23 Ocean COA second submission

Site Plan Conditions of Approval

**L-2.0**

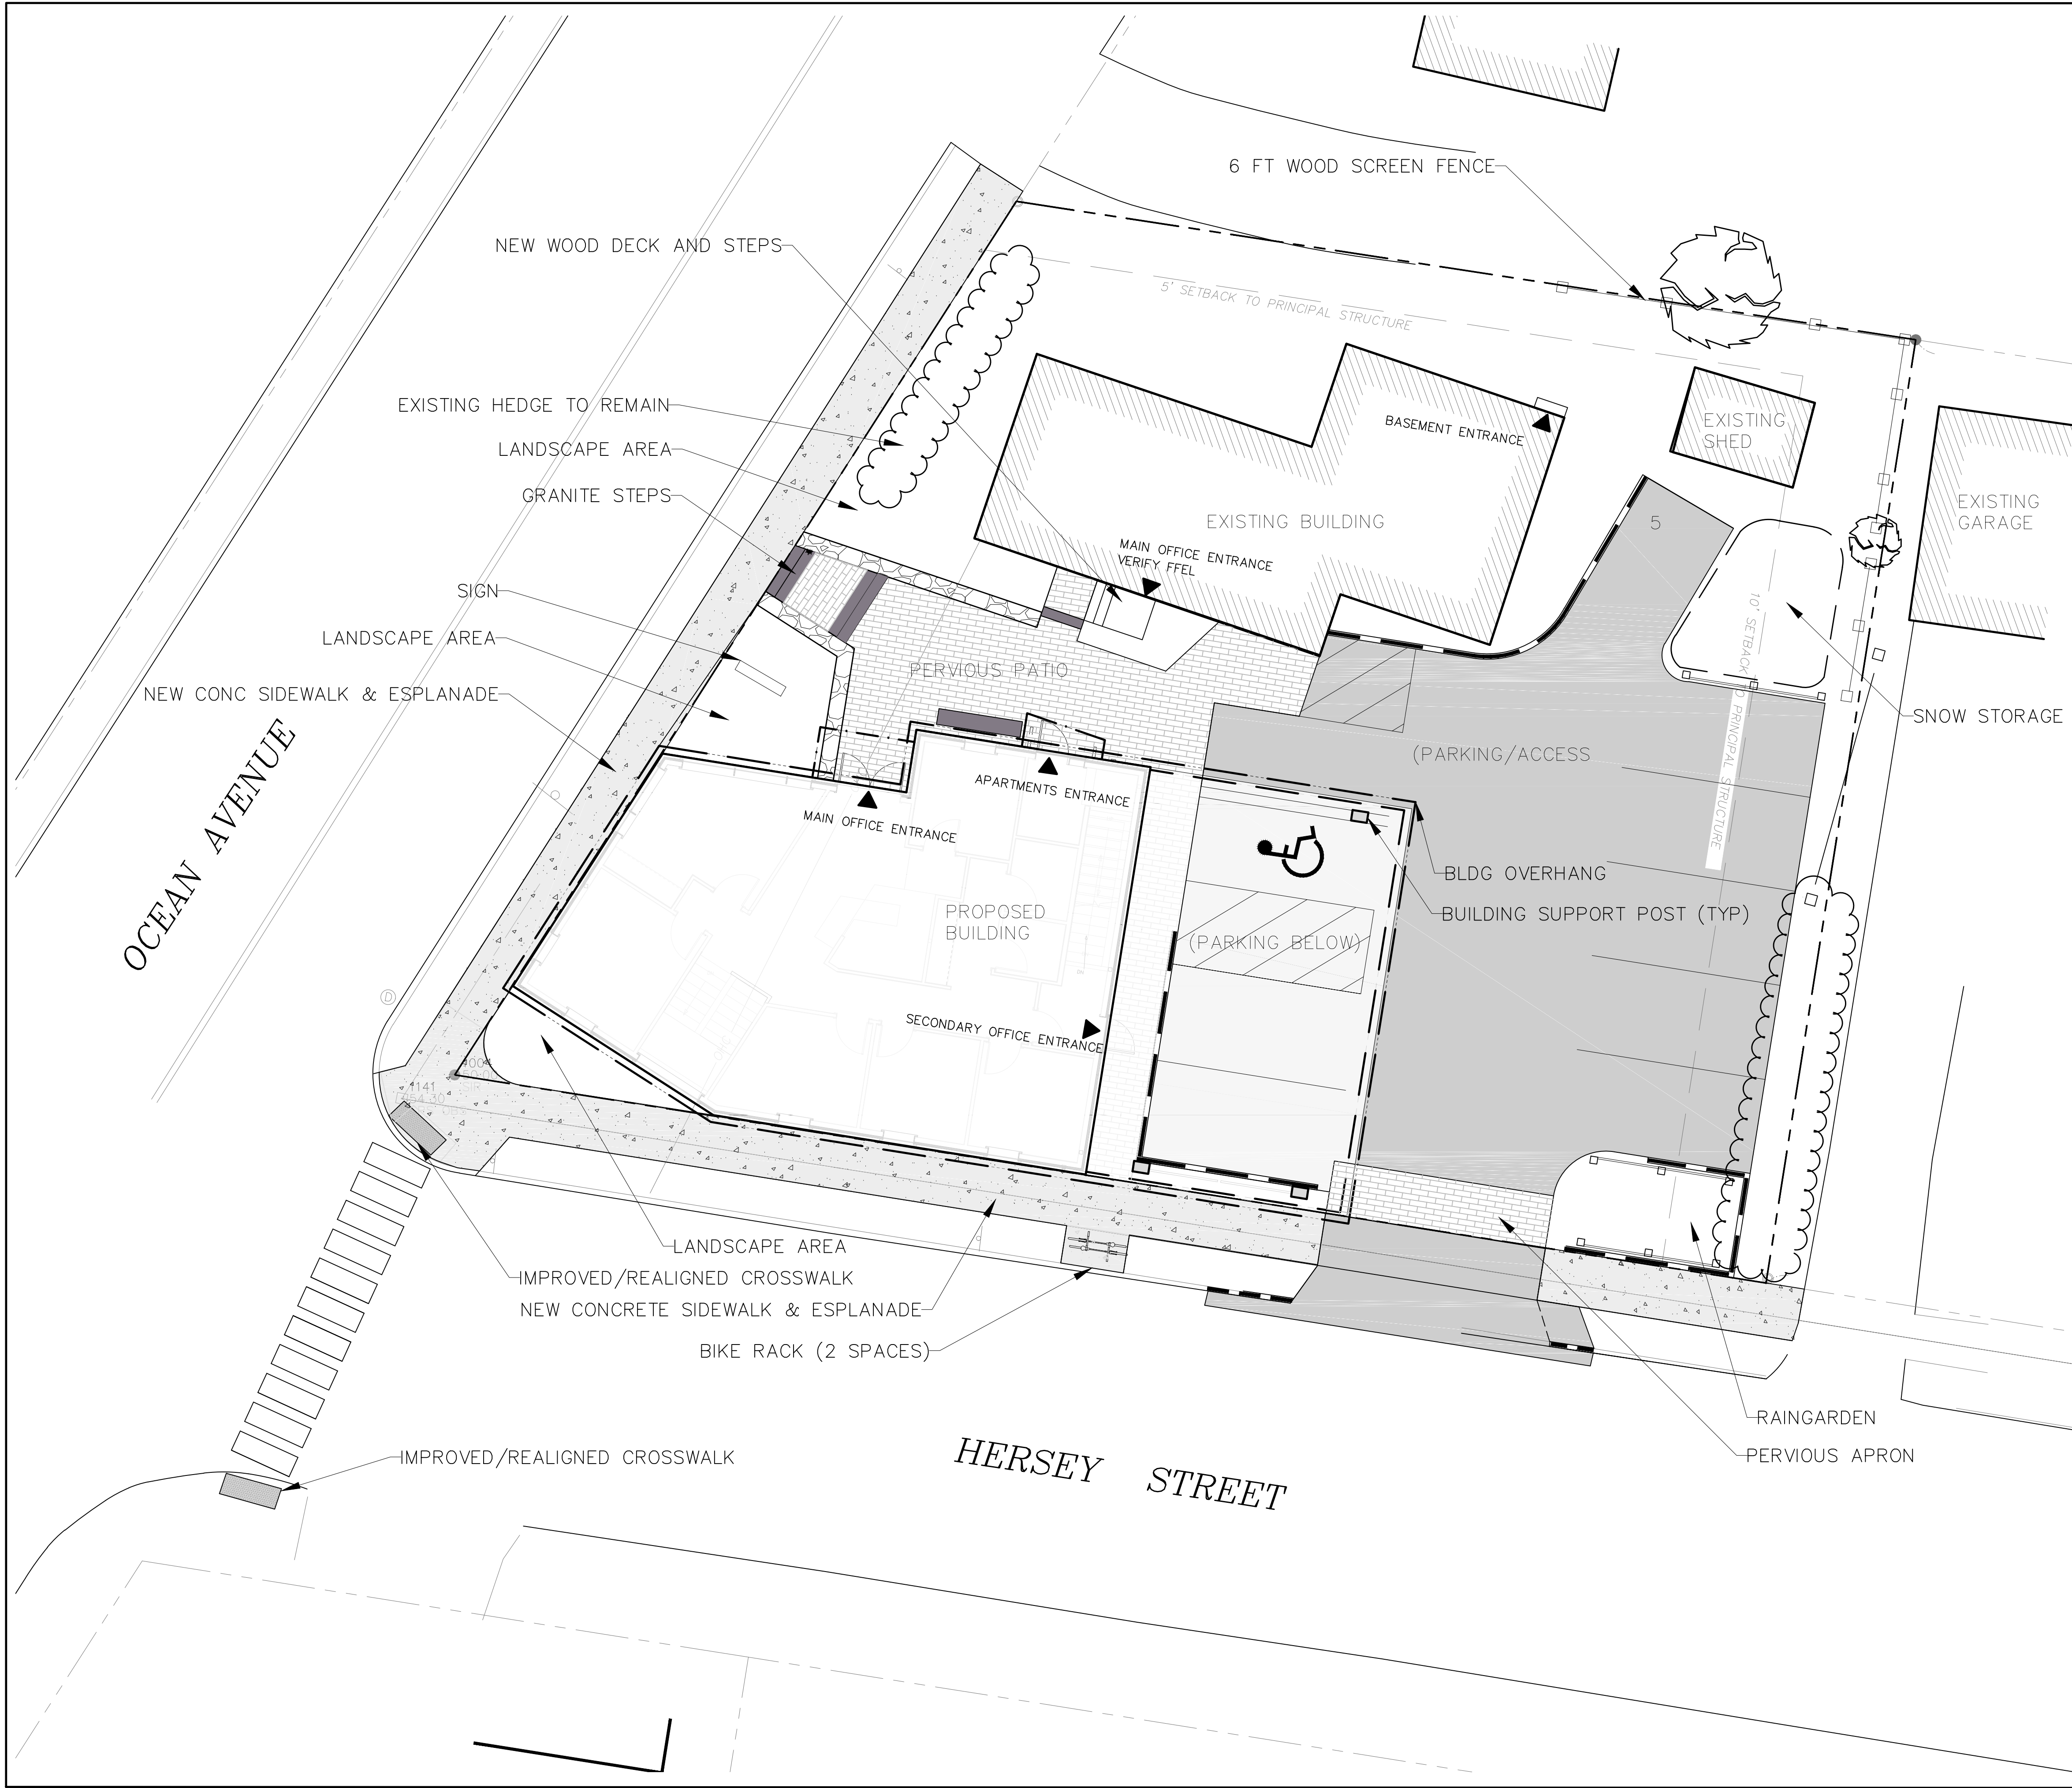
6. Snow storage

- | | 1. Shown on sheet L2.0 included in the zip file.

Job Number:
File:
Date: 09-02-2016 **Scale:** AS SHOWN
Drawing Number:
L-6.0
© 2016 CARROLL ASSOCIATES

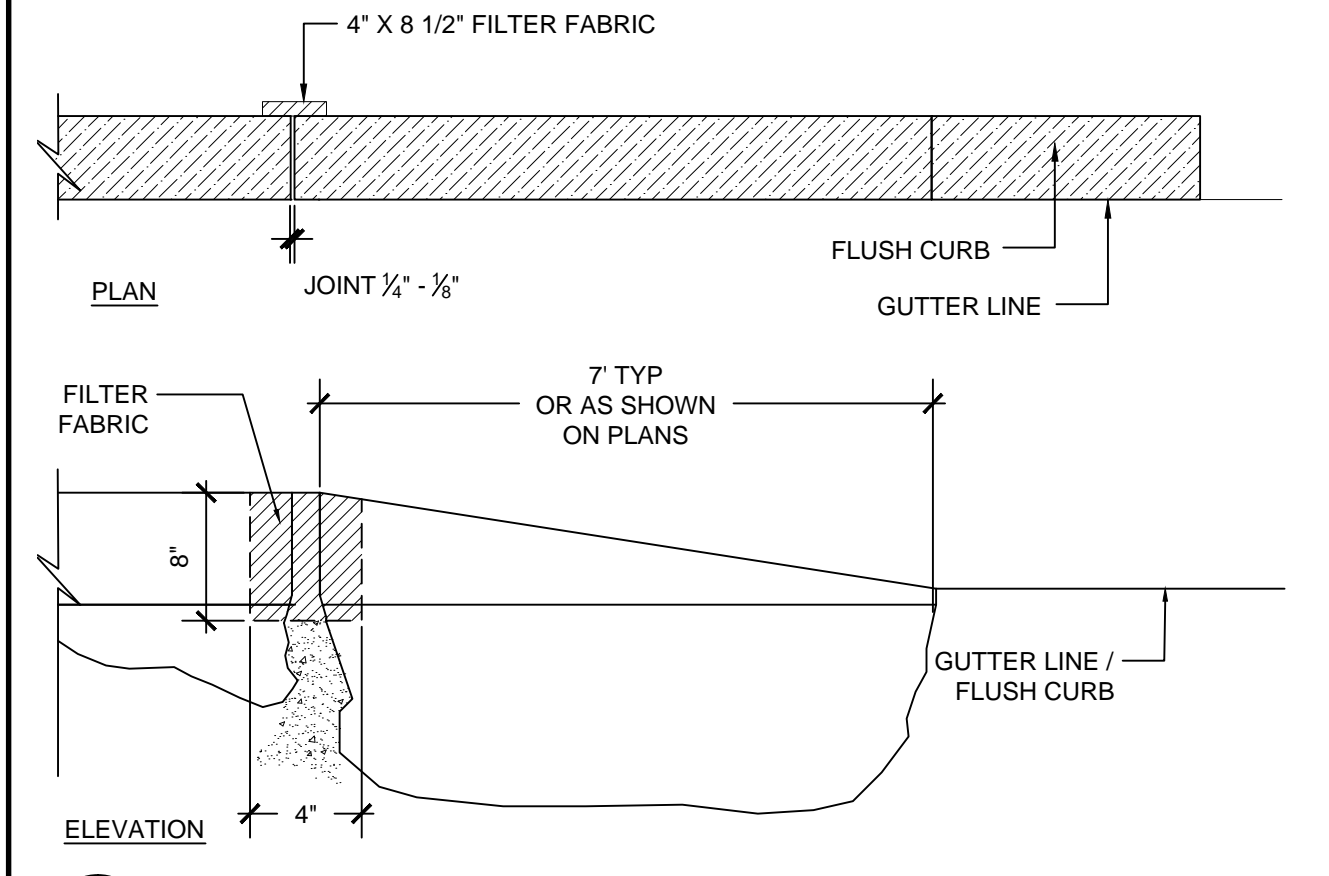
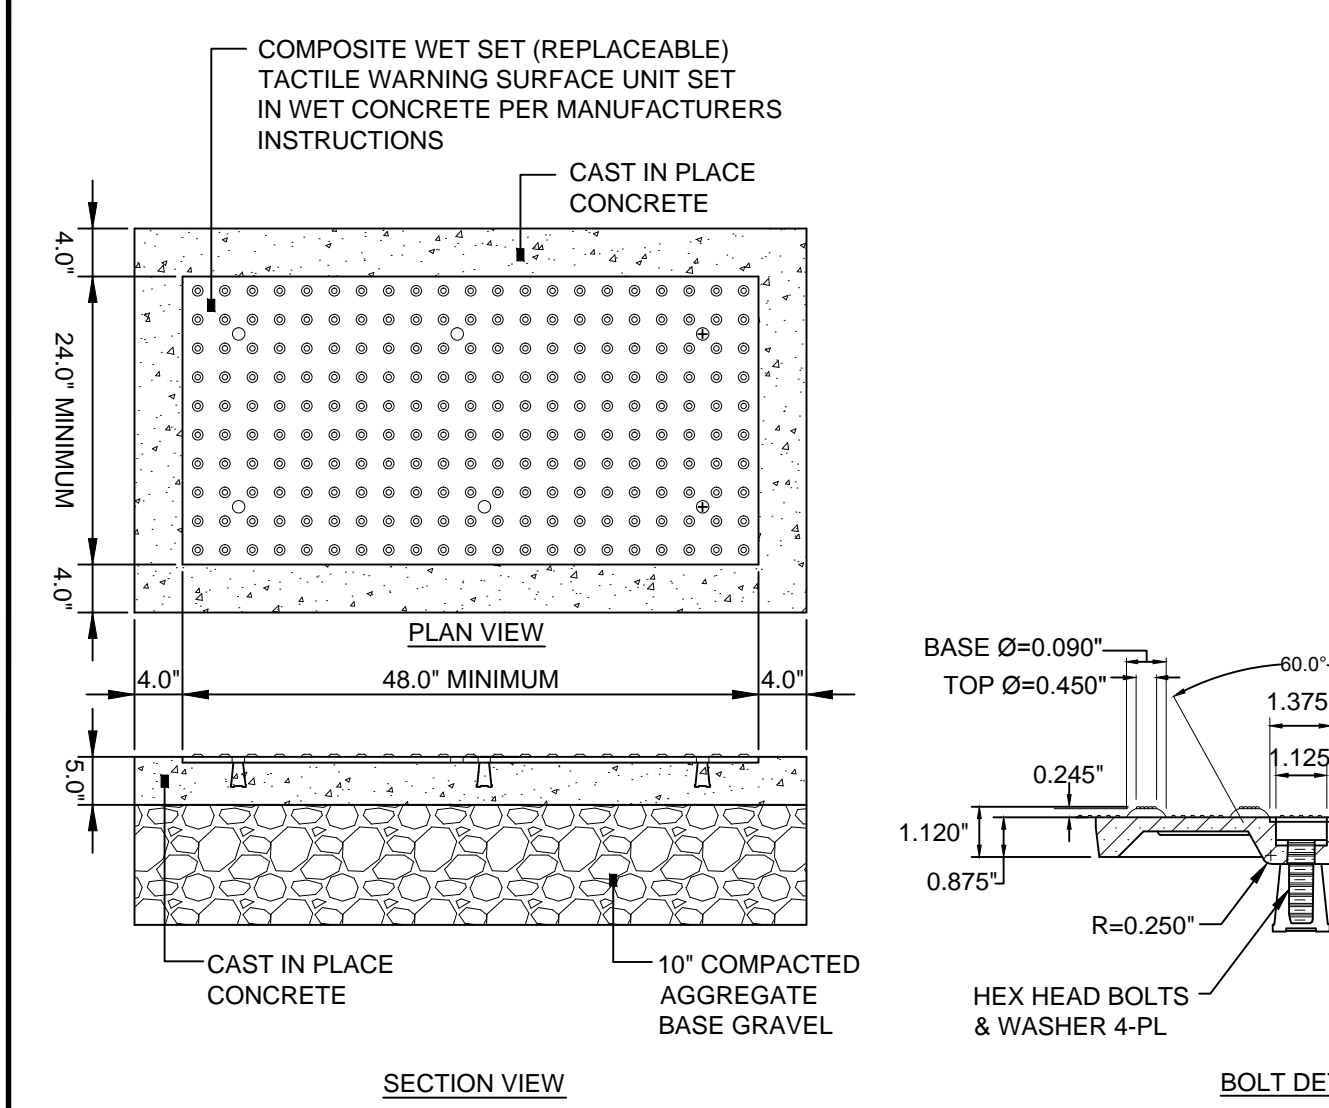
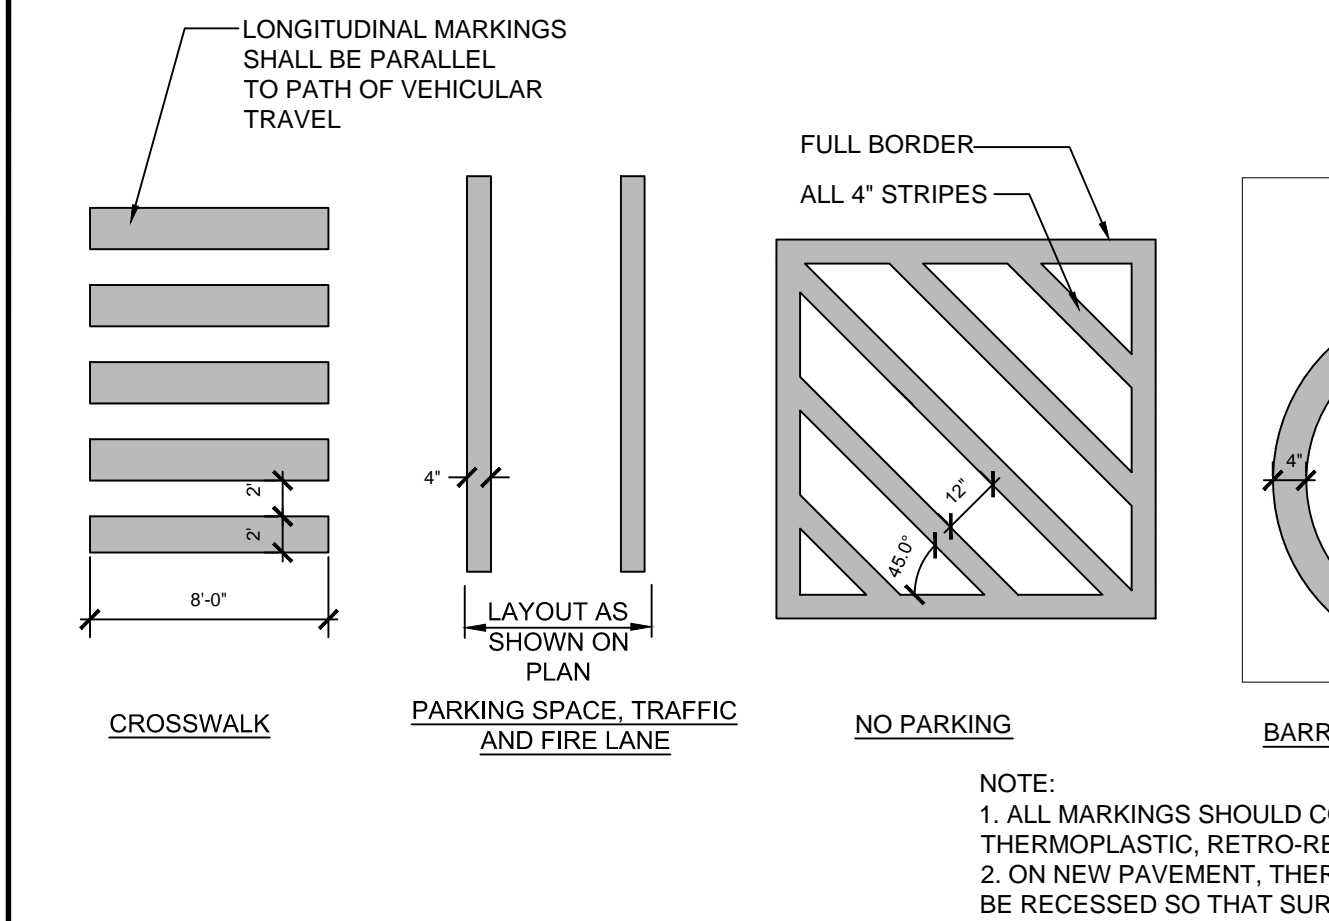
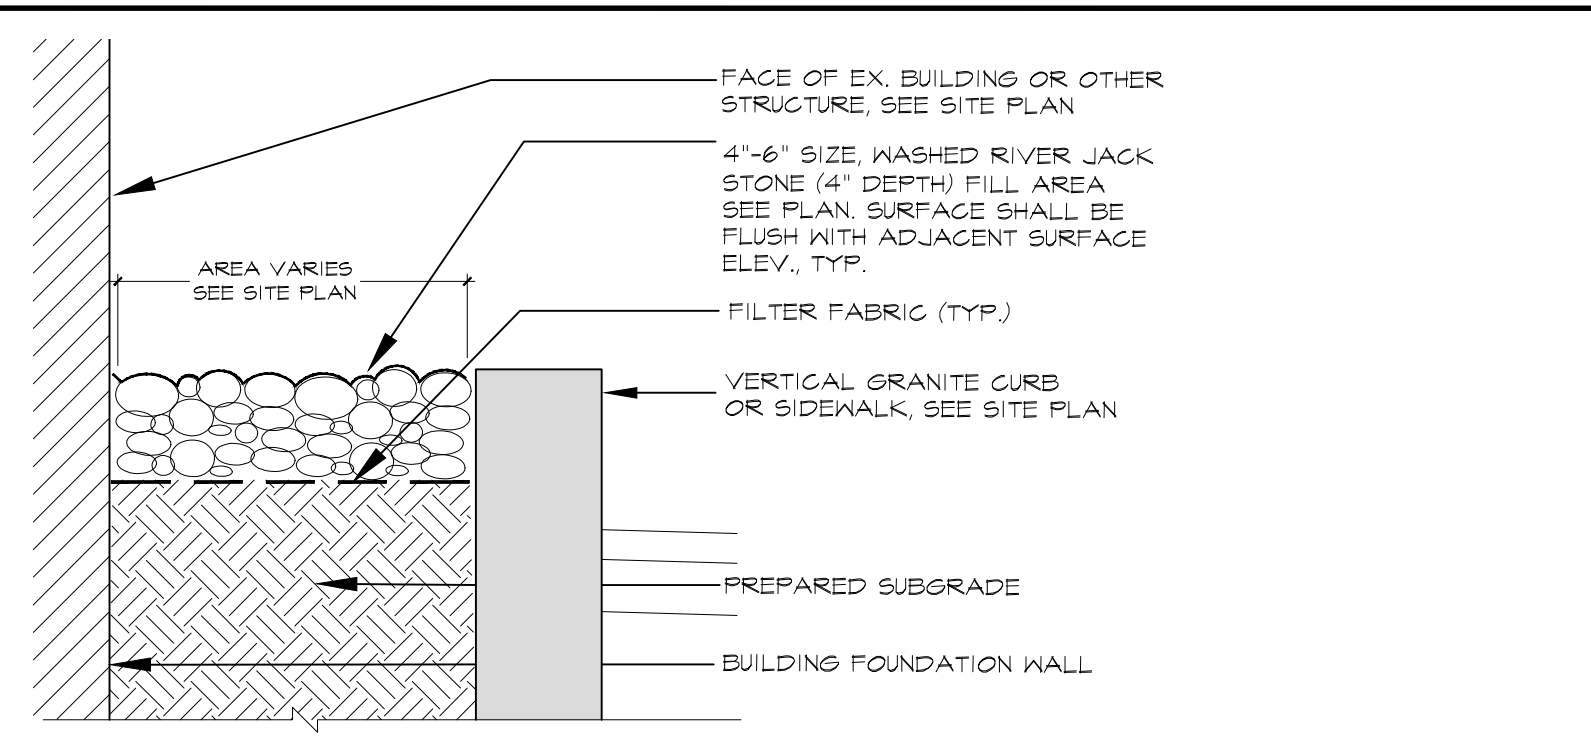
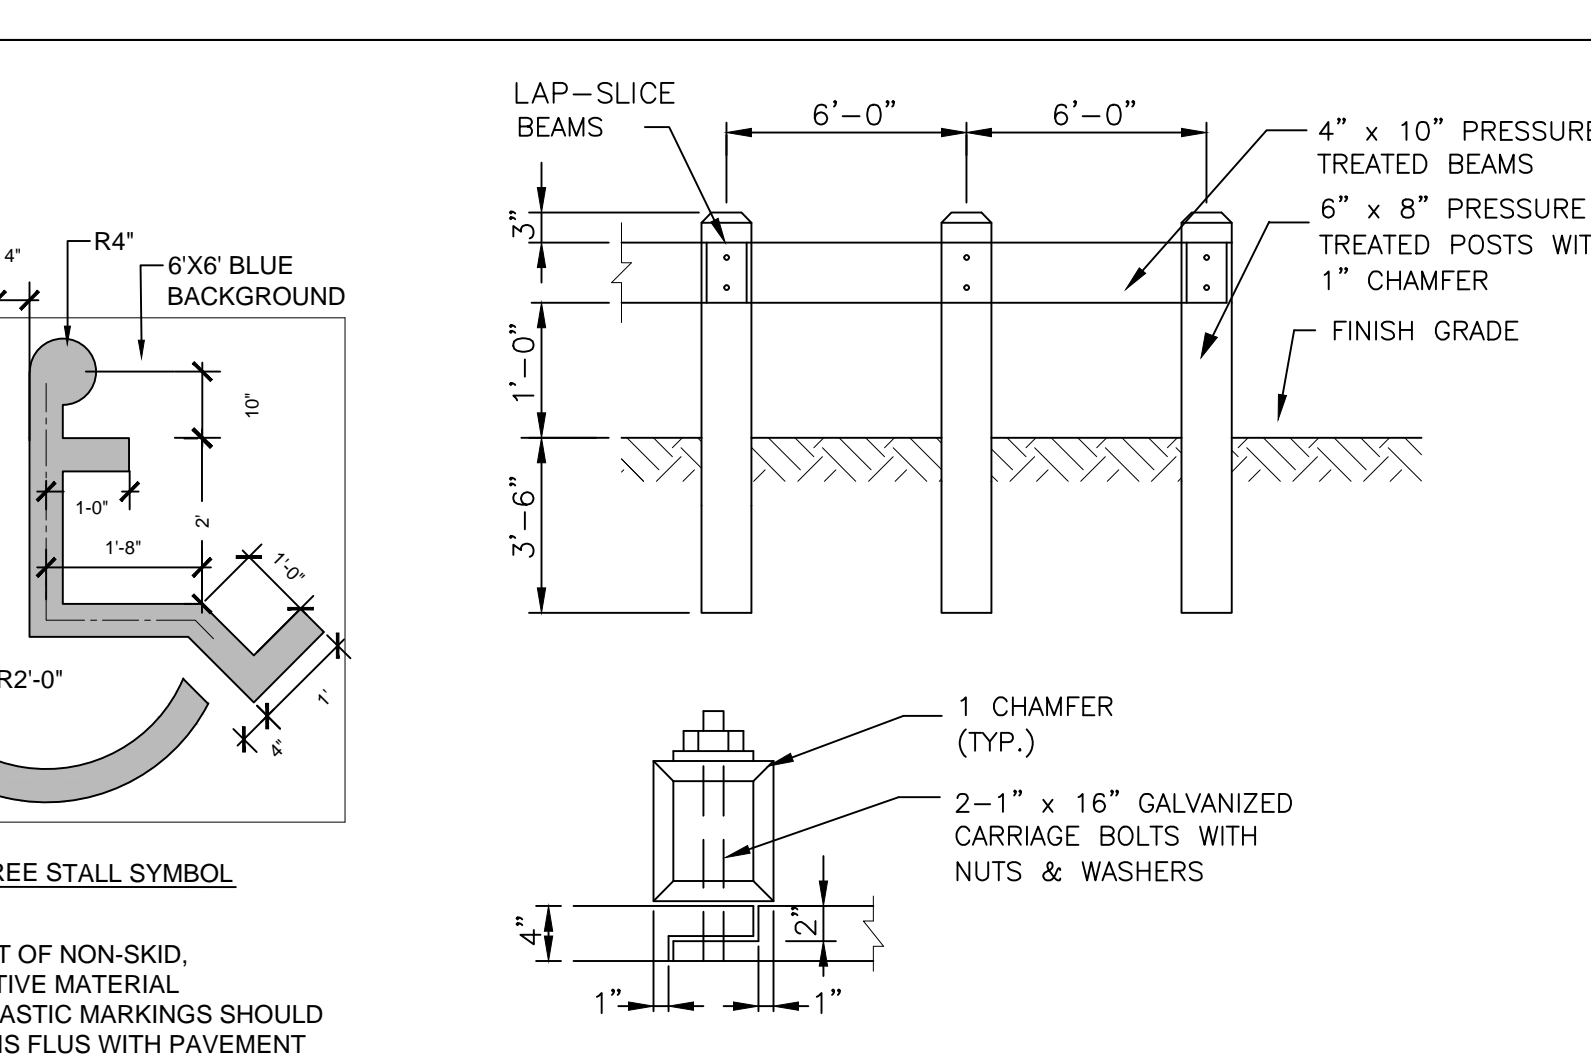
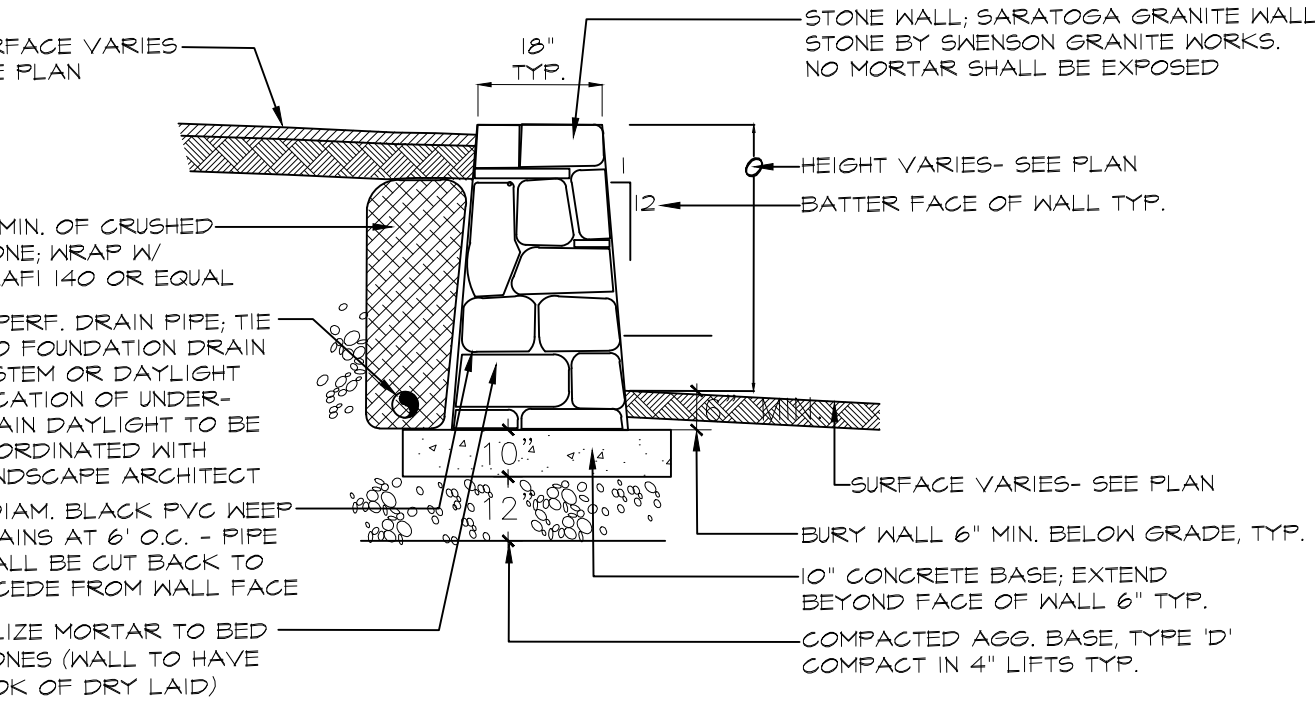
TE's comments on ramp design attached. John should feel free to be in touch with Tom if he has questions.

John has visited the site and conferred with Tom Erico to confirm the design. Landscape drawings attached incorporate the design as reviewed with Tom.
